January 4, 2024

RE: Residential Building Permit Intake Combine Notes – Intake Screening # 2311-047

Parcel Number: 362550-0210
Rene Lund – Fire Restoration and Addition
8520 SE 82nd ST
Mercer Island, WA 98040

LOWER LEVEL SHEAR WALL PLAN
SCALE 1:64

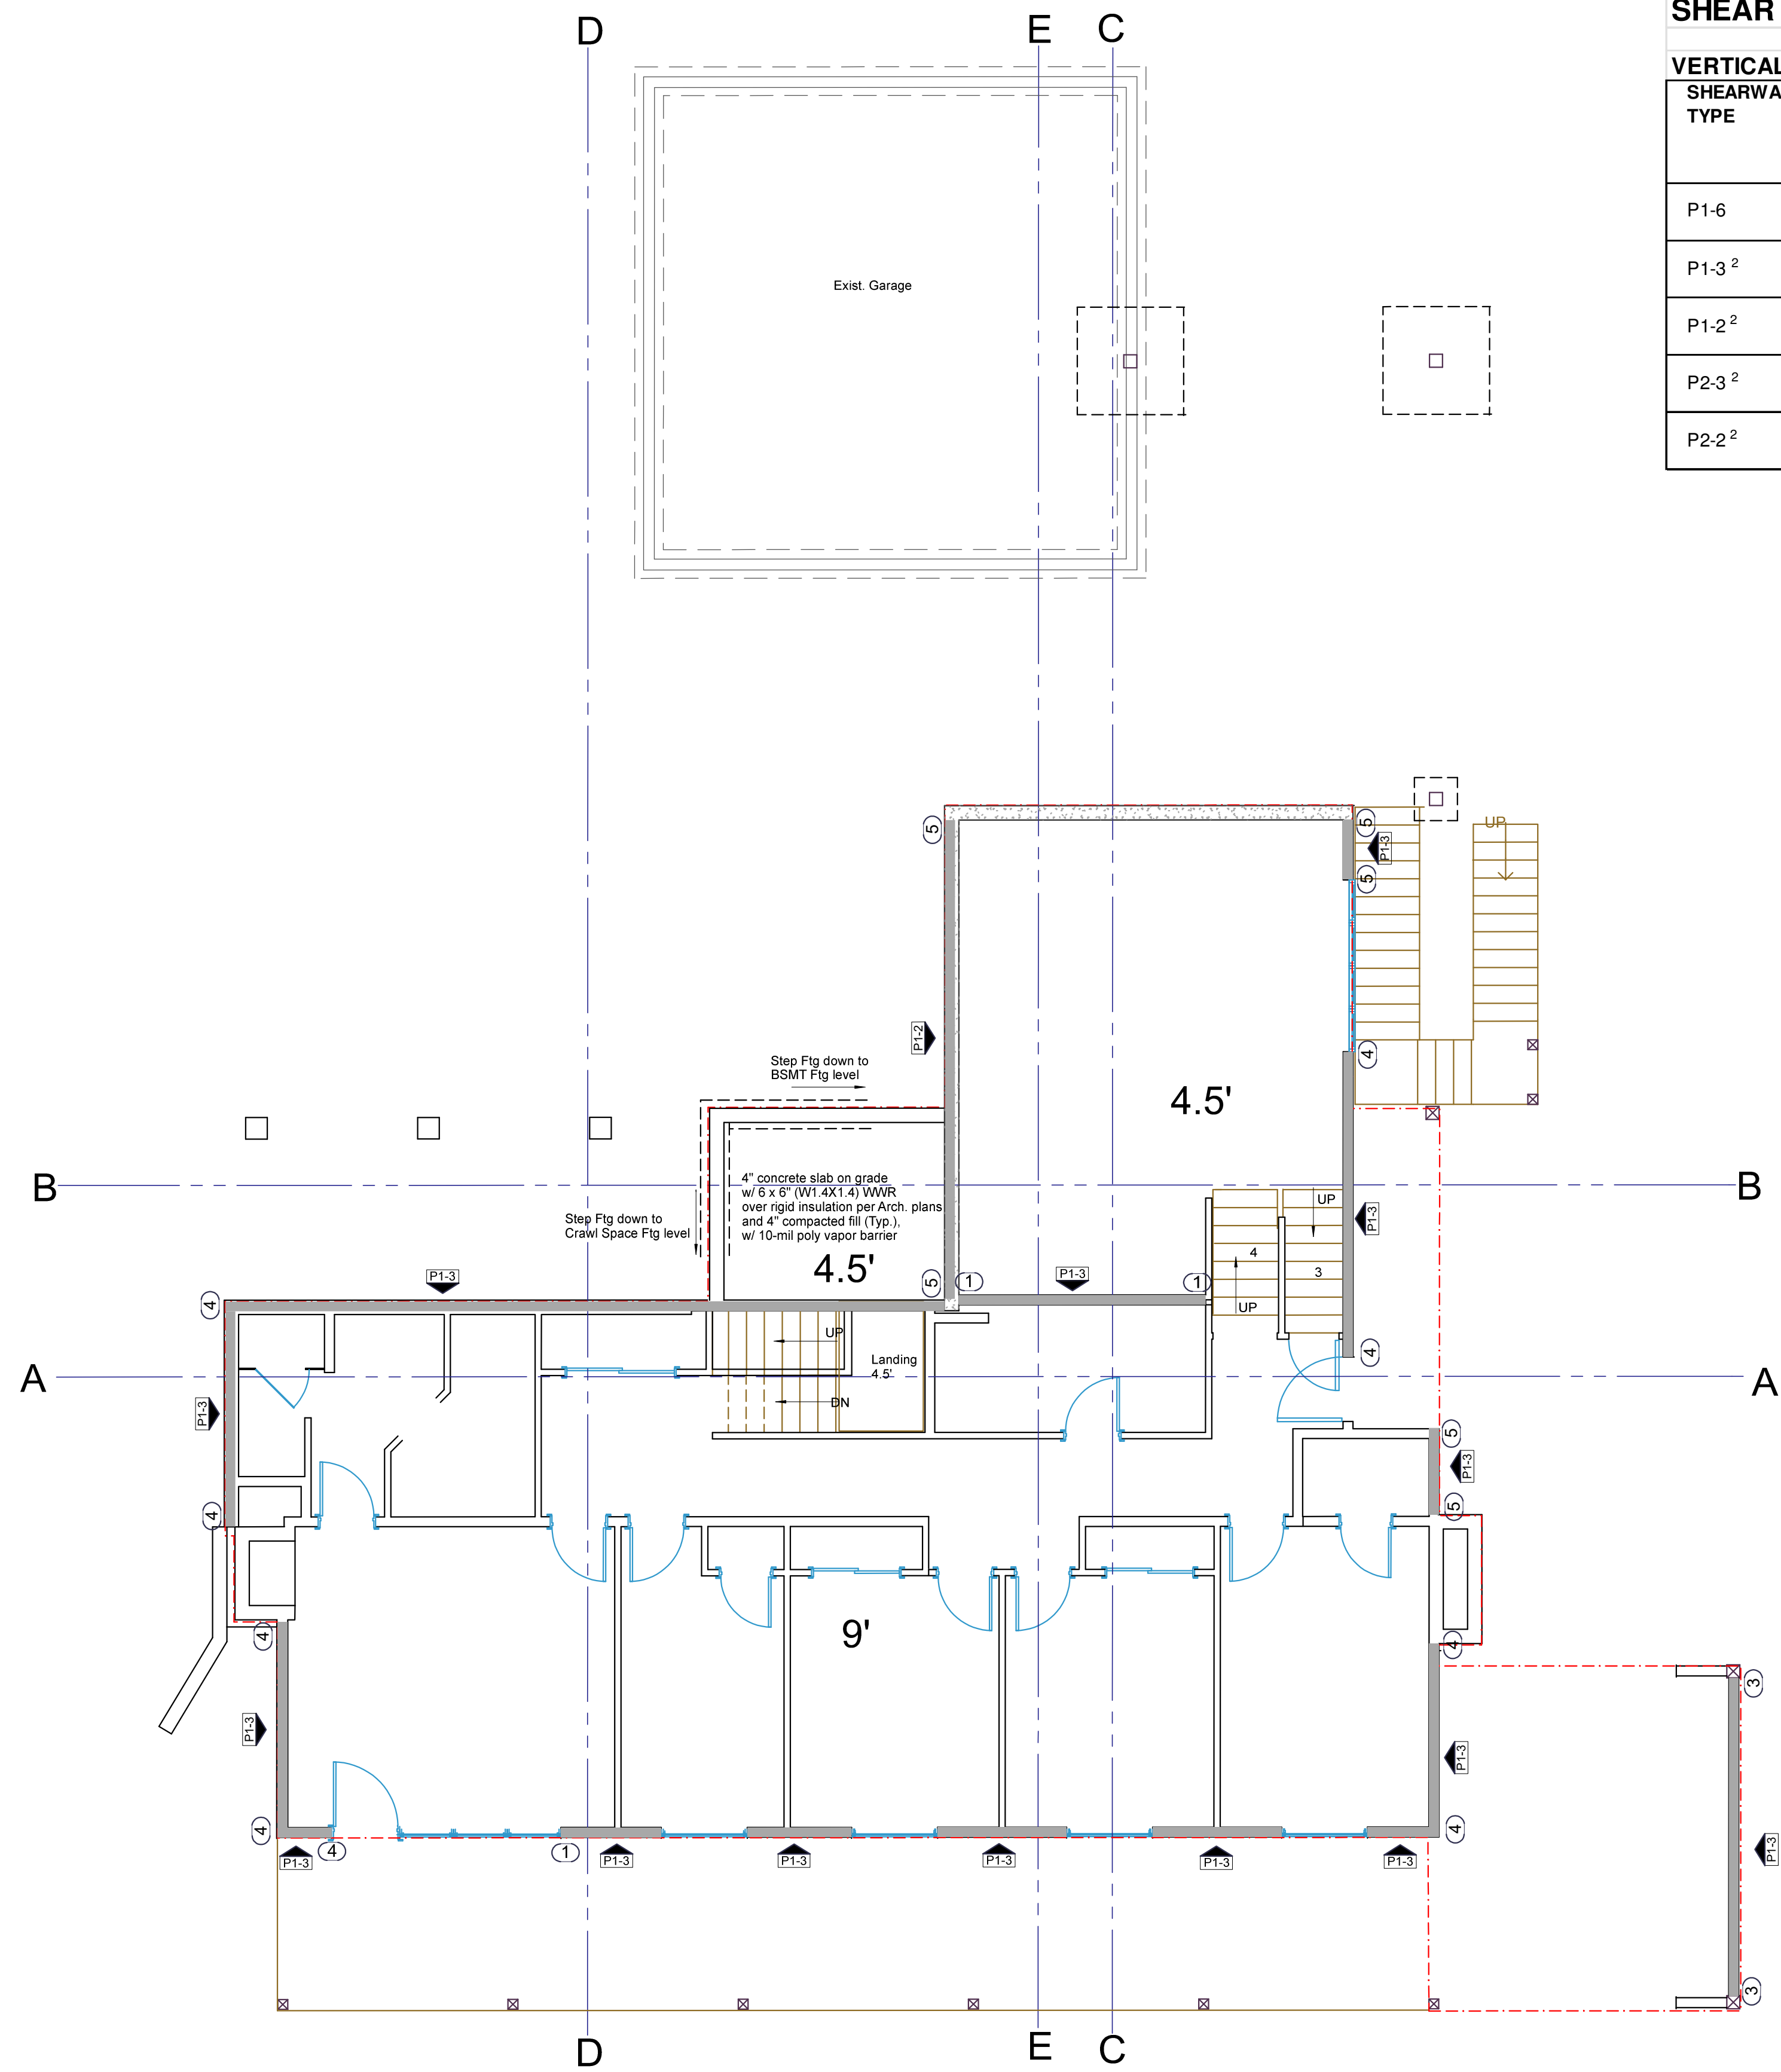
2. Building Division
 - a. The structural design was updated to reflect the required lateral design corrections for the adequate wind speed as required per the intake comments.
